Comments from Kirkby Thore Parish Council for Deadline 8

Document REP7-142 "Scheme 0405: Temple Sowerby to Appleby, TR010062, 5.23 Traffic Regulation Measures (Speed Limits) Plans (Rev 2)" was submitted to Deadline 7 on 9th May. Kirkby Thore Parish Council (KTPC) notes that the majority of the length of the current 40mph speed limit along the existing A66 is proposed to be reduced to a 30mph limit. However, as shown on the attached Sheet 2 of the document, a short length to the west will be raised to a 60mph limit. This length includes the access to a working farm, Street House Farm, a junction with a road into Kirkby Thore along Piper Lane and a dwelling adjacent to the Piper Lane junction. KTPC requests that the current 40mph limit along this short length be retained, in order to maintain the same level of safety for ingress/exit of tractors to the farm and to provide a more natural slowing of the traffic from 60mph to 30mph as it approaches the village.

Drawing Title
TRAFFIC REGULATION MEASURES
(SPEED LIMITS) PLANS
REGULATION 5(2)(O)
SHEET 2 OF 7

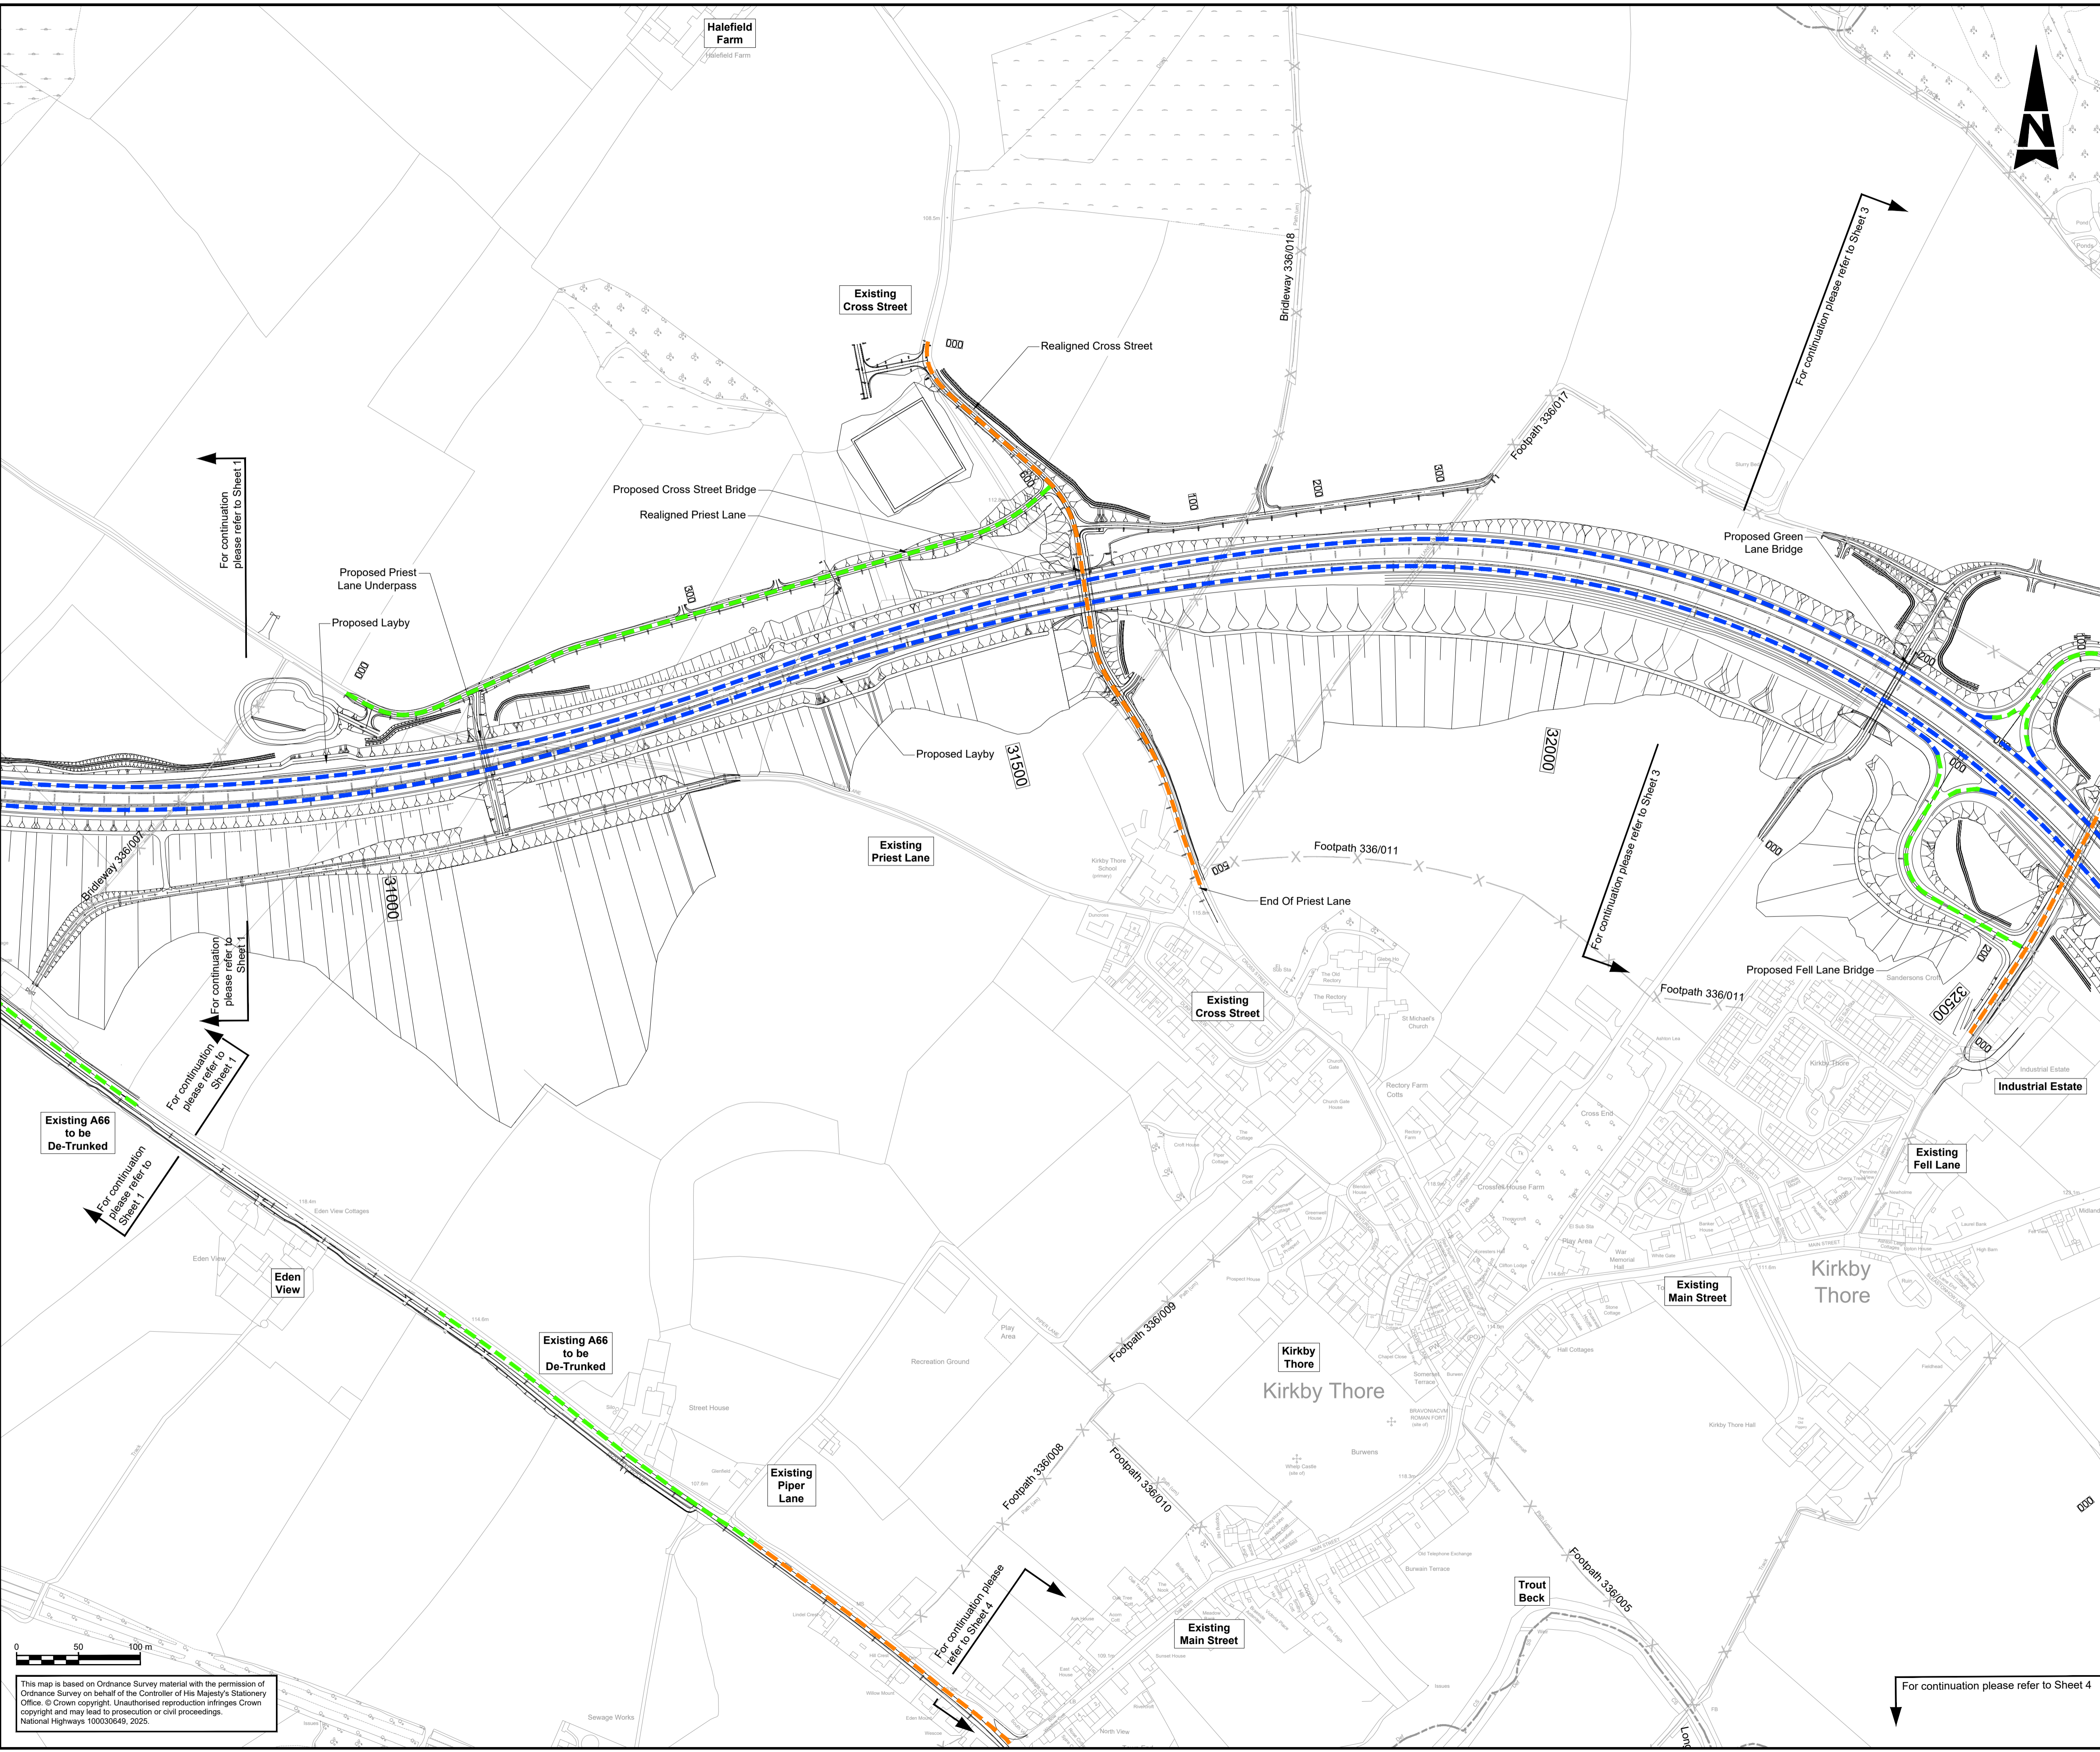
In addition, KTPC understood that the DCO proposed the designation of Priest Lane as a Quiet Lane, a mixed-use road suitable for the use of walkers, cyclists and horse riders as well as vehicles and was very supportive of this change owing to the current poor provision of off-road PRow in this area. Linked to this suggestion, KTPC also thus very much supported the proposal in the recent National Highways proposal re. DC-10 (which is not now being taken forward) to reduce the speed limit from 60 to 30mph along Priest Lane in the same way that is still proposed in DC-14 for Sleastonhow.

KTPC still considers that a reduction in the speed limit to 30mph is necessary along Priest Lane, as well as along Sleastonhow, and that this suggestion is consistent with the approach Highways are taking along Sleastonhow in DC-14 which shares similar issues. Priest Lane is the main route taken for people walking from the village to the Health Centre in Temple Sowerby, it is also much used for circular walks from both Temple Sowerby and Kirkby Thore villages, with routes running along Priest Lane to Temple Sowerby and back round via Newbiggin village, returning to Cross Street. Priest Lane is also part of the promoted long distance walking route called Lady Anne's Way which runs from Skipton to Penrith and has become very popular in recent years and brings many walkers from all over the country into Kirkby Thore and Temple Sowerby along this ancient routeway with its well-known associations with Lady Ann Clifford. Priest Lane is a much-cherished walking route with magnificent views along its length of the striking and highly distinctive scarp face of the North Pennines AONB, and it deserves highly sensitive treatment in the proposals, including a reduction in the speed limit to 30mph. This would ensure that this popular route became far safer than it is currently for the many walkers who use this road. In addition, KTPC wishes to see the Rural Road Design Guide being used for Priest Lane in the same way that is proposed for Sleastonhow. We do not wish to see a design which would result in widening and the loss of the current rural character of this ancient route, or the introduction of inappropriate urbanising infrastructure.
